## Jacfin Pty Limited – Part 3A Project Application (No. 07\_0153)

### Response to Submissions

Figure 14 – Schematic section of proposed creek crossing

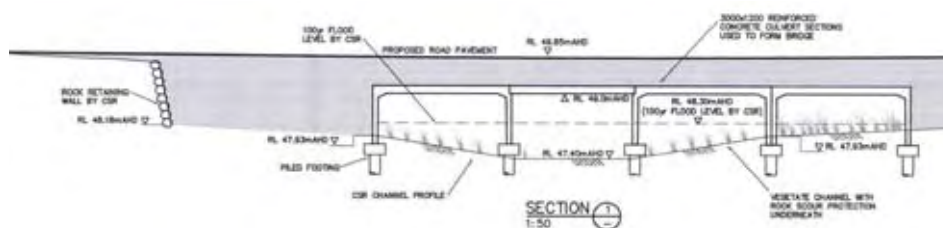
(a) Non-compliance with Council's minimum standards in relation to the constructed road width and bridge crossing are not supported. Plans depicting a 13m wide carriageway, cul-de-sac radius of 16.5m and centrally located carriageway with 3.5m wide verges either side (with 2% fall to the kerb) are requested.	(a) (i) The Templar Road extension is proposed to provide access to Lot 11, DP 229784 which is owned by Jacfin. Originally Templar Road was proposed by CSR as a 10.5m wide right of way solely to provide access to the Jacfin site. This was because that site's only legal right of access was to be extinguished as a result of a plan proposed by CSR to convert a designated Crown road reserve to an environmental conservation area.  Such a conversion would have been of benefit to the land holdings of CSR and the only way that this would be achieved was to provide alternative access for the Jacfin site. The Crown Road Reserve was the only form of road access available to the Jacfin site at that time.

Issue	Response	Addressed in EA
	<p>The reduced width of the bridge is proposed for environmental reasons to reduce the loss of sunlight falling on the water course beneath to an absolute minimum.</p> <p>The report by Dr Stephen Webb for this application has established that the proposed crossing conforms to DWE riparian guidelines, provides sufficient waterway area to not impact on flood levels, and is designed appropriately not to impact on the stability of the creek bed. In this regard, whilst PCC may have minimum general standards this needs to be balanced with other environmental planning considerations such as the integrity of the relocated creek crossings.</p> <p>(iv) In response to PCC, Jacfin contends that in applying any DCP it is normal to look at the circumstances of the case before deciding whether to strictly apply the provisions of the DCP. In the particular circumstances of this case:</p> <ul style="list-style-type: none"> <li>• The Templar Road extension was only proposed because the Jacfin site was to be denied access from the then existing Crown road reserve.</li> <li>• The Templar road extension was only ever envisaged as providing access solely to the Jacfin site.</li> <li>• Both Jacfin and Penrith Council preferred that a dedicated public road be provided.</li> <li>• Nevertheless, the only functional requirement for this road was to provide access to the Jacfin site.</li> <li>• At no time was access to any other land from Templar Road anticipated. As such, it is not provided for in the Concept Approvals for other land on each side of the Templar Road extension.</li> <li>• In view of this, and to avoid unnecessary capital and maintenance costs and also to avoid excessive stormwater runoff, the carriageway of the Templar Road extension should be designed not to meet some pre-existing generic formula, but rather to meet</li> </ul>

Issue	Response	Addressed in EA
	<p>the needs of the purpose for which it was intended.</p> <ul style="list-style-type: none"> <li>• The proposed design with a 7m wide carriageway does this appropriately.</li> <li>• The width of the bridge has been determined to achieve an optimum environmental outcome for the waterway beneath and adjacent to it.</li> </ul> <p>All of these considerations support the current proposed design of the Templar Road extension in preference to the requirements of Penrith Council's generic DCP.</p> <p>(v) While the design of the Templar Road extension does satisfactorily meet the needs of the Jacfin development, it is apparent from the GPT submission (that contrary to the approved CSR Concept Plan), there could be other uses of the Templar Road extension.</p> <p>The application made for the Templar Road extension now proposed would allow the relatively easy widening of the carriageway to the DCP's full carriageway requirements in future. The bridge crossing, because of its location, would only need to serve the Jacfin site.</p> <p>It is therefore proposed to construct a 7m wide carriageway to serve the Jacfin site with a 3.5m rather than 4.5m offset from the boundary on one side. A revised plan (5269-02-03 Issue: L) showing this amendment is attached to this Response to Submission and this plan should be incorporated by way of a condition of consent. This realignment would allow the carriageway to be widened to 13m if needed at some time in the future. Any such widening is not a part of Jacfin's application; this would be a matter for any future development of the adjoining land.</p>

Project: **PROPOSED WAREHOUSE & OFFICE FOR WATERHOUSE** Title: **LANDSCAPE PLAN**
 Address: **LOT 11 DP.229784 TEMPLAR ROAD ERSKINE PARK NSW 2208**

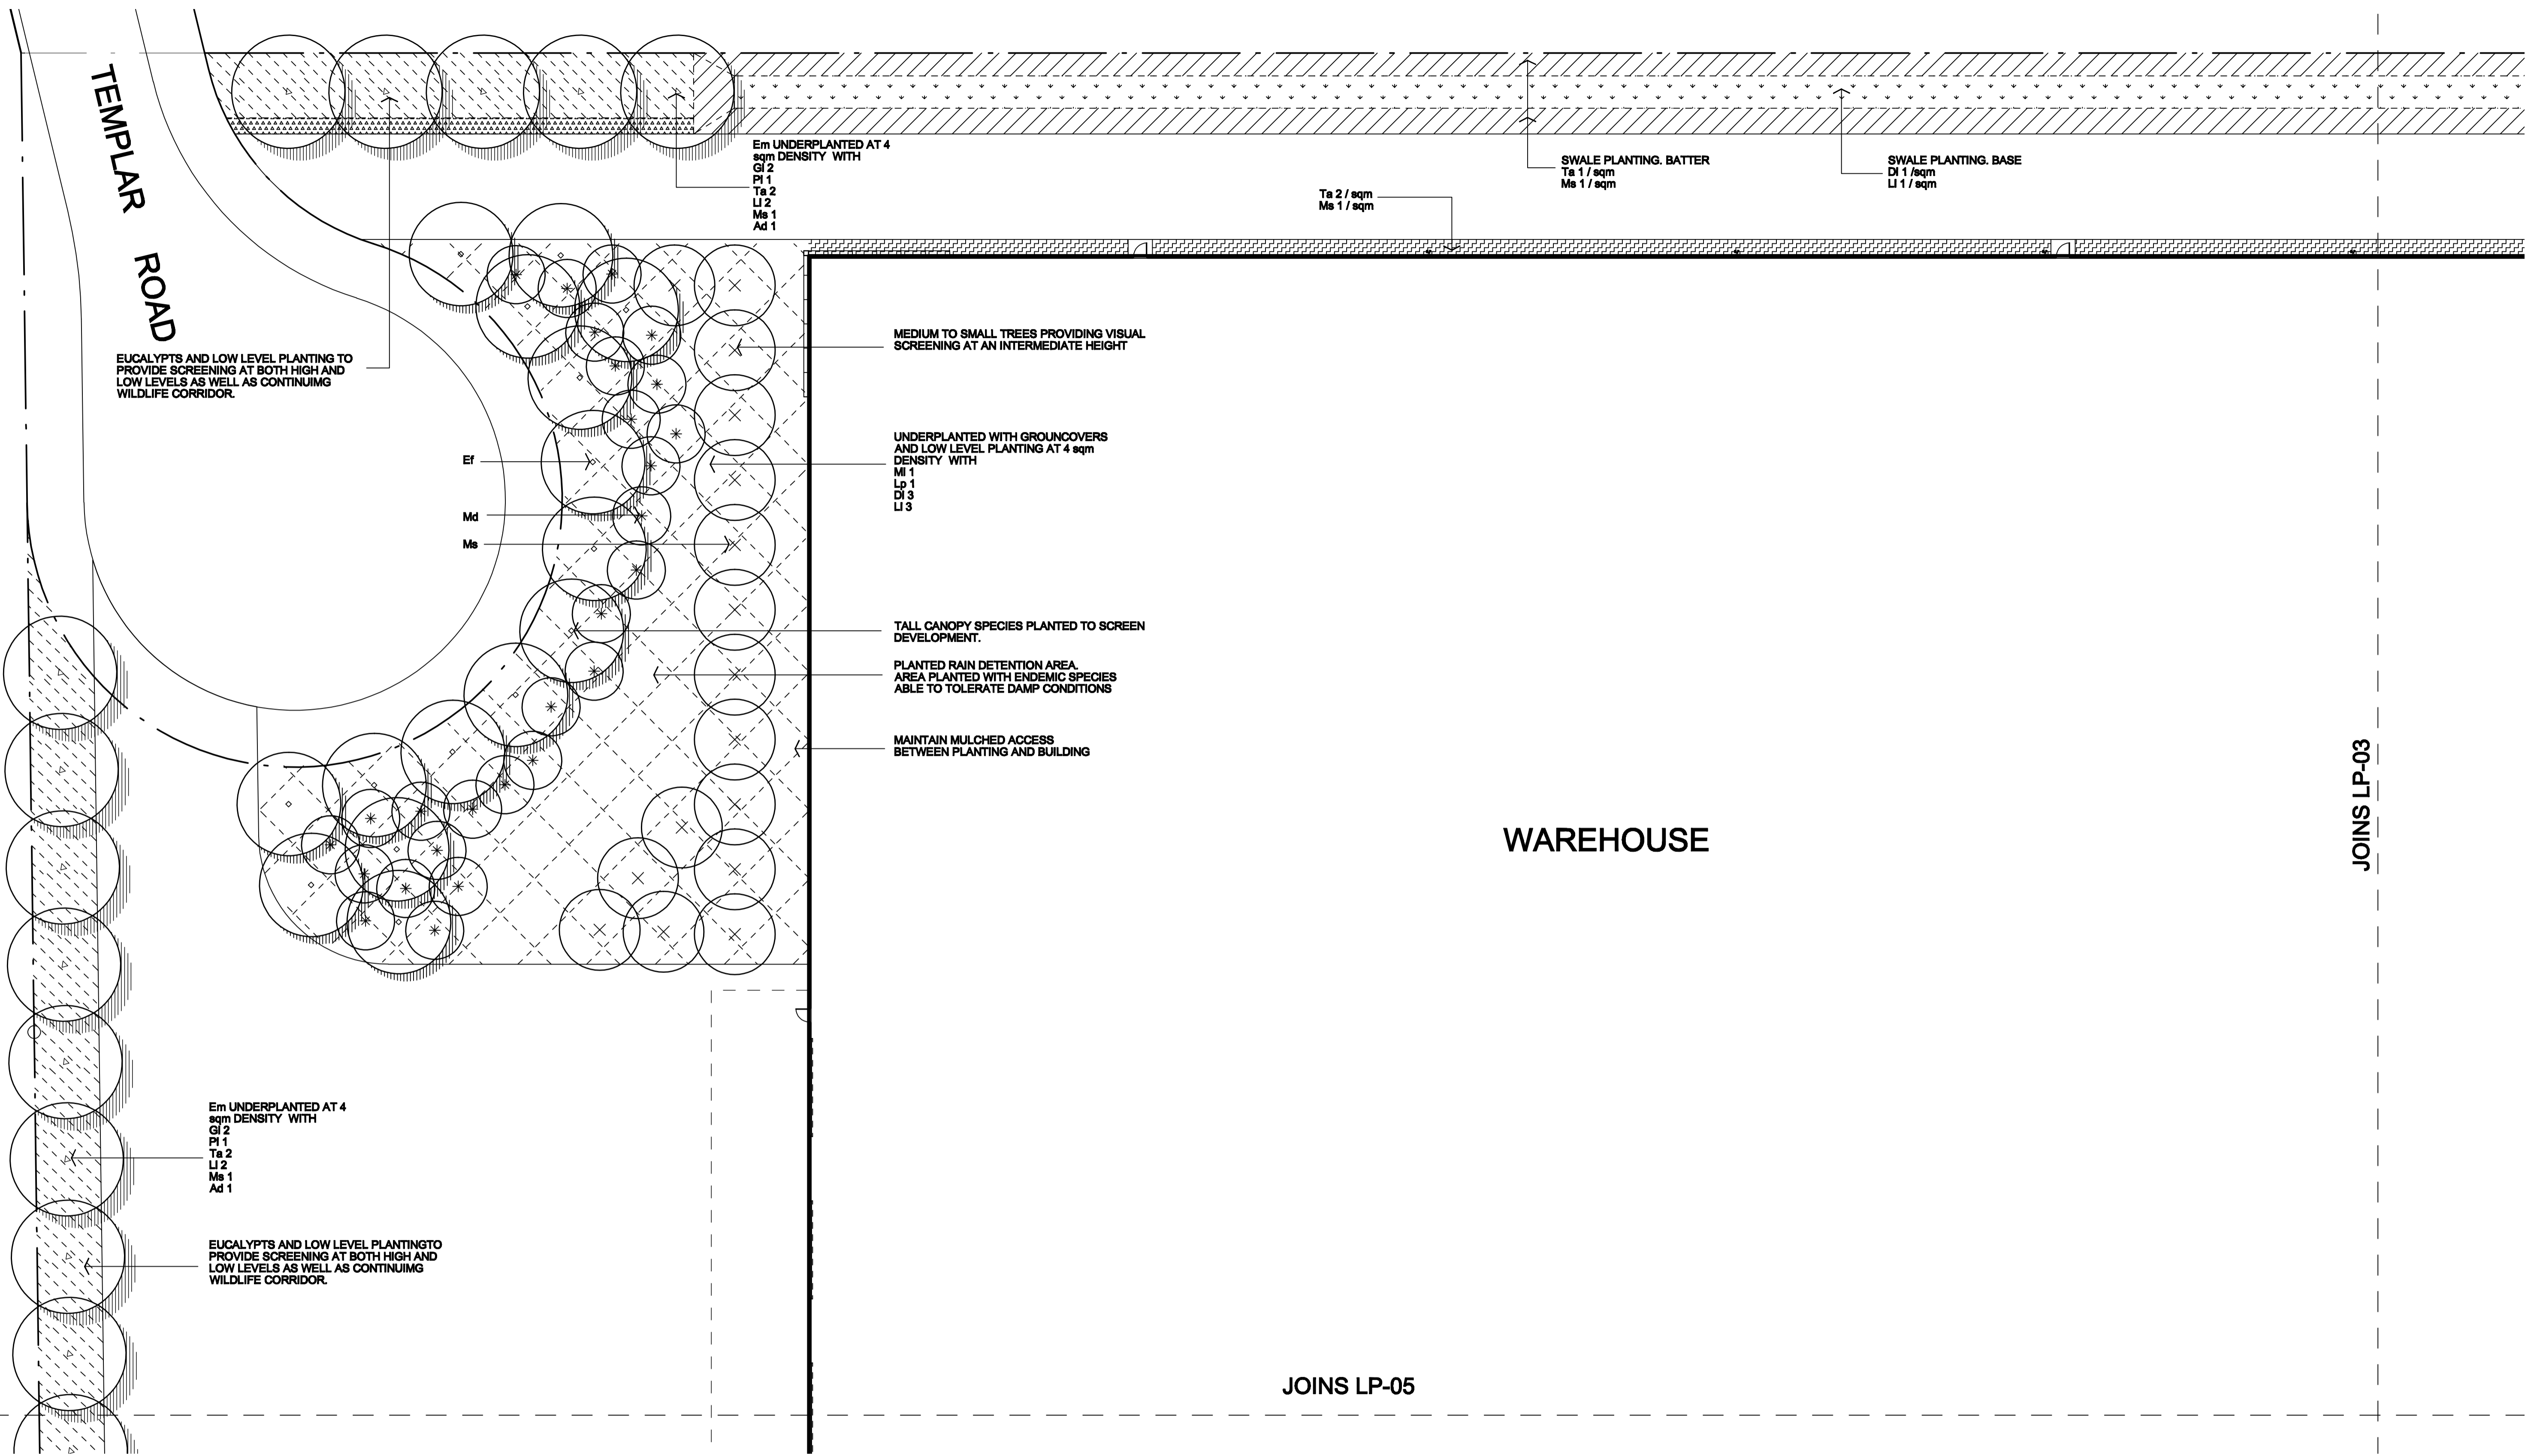
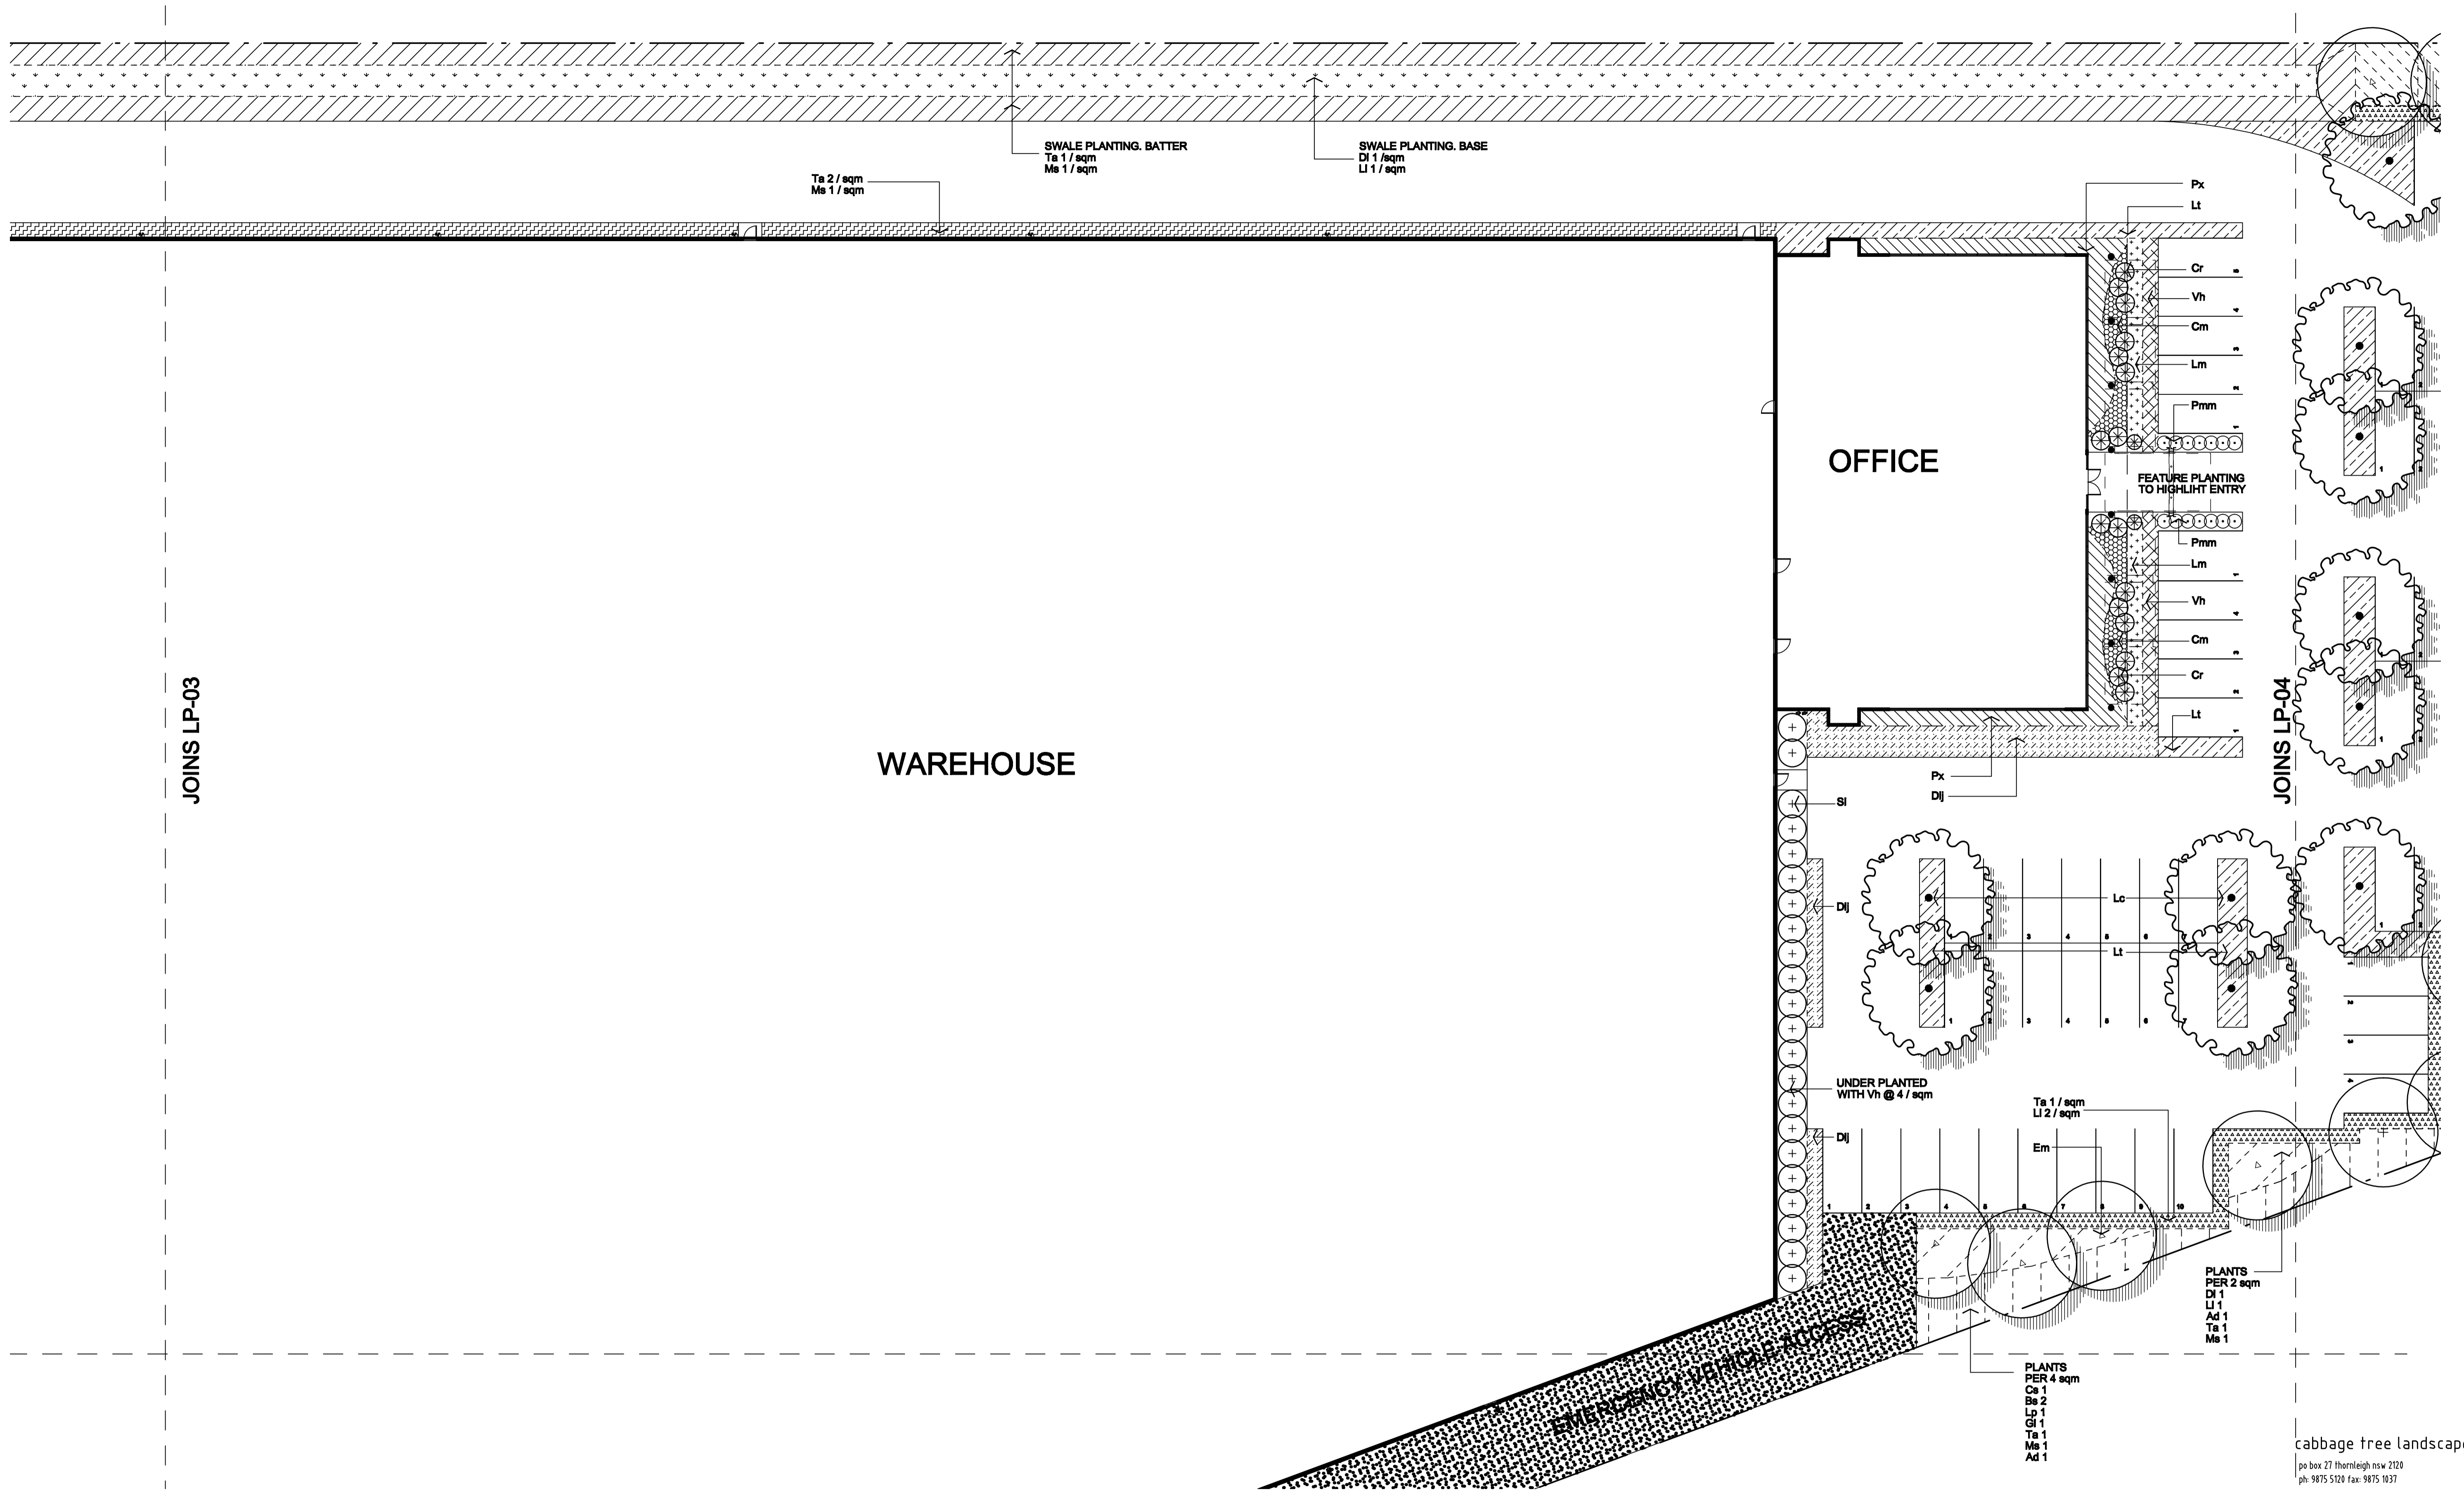
Issue	Response	Addressed in EA
<b>Ivan Jeray (private individual)</b>		
<p>(a) Non-local native plants (including hybrid and cultivar species) proposed in landscaping plans are not supported.</p>	<p>(a) The Landscape Plan for the site was prepared in accordance with the <i>Flora &amp; Fauna Report</i> recommendations, which were based <i>inter alia</i> on the Penrith City Council DCP (2006) and the NPWS <i>Technical Report on the Native Vegetation of the Cumberland Plain, Western Sydney</i> (2000).</p> <p>In this regard, the proposed landscaping for the site is considered suitable and compatible with the locality. It is also noted that neither Penrith Council nor the DECC (which absorbed the former NPWS) have objected to the proposed landscaping.</p> <p>Introduced and non-local native plants are not regarded as problematic in an industrial landscape. In the case of cultivars, the final Landscape Plan will be refined to ensure that cultivars used do not compromise any indigenous plants.</p>	<b>Section 6.4, 6.10, Appendix D.</b>
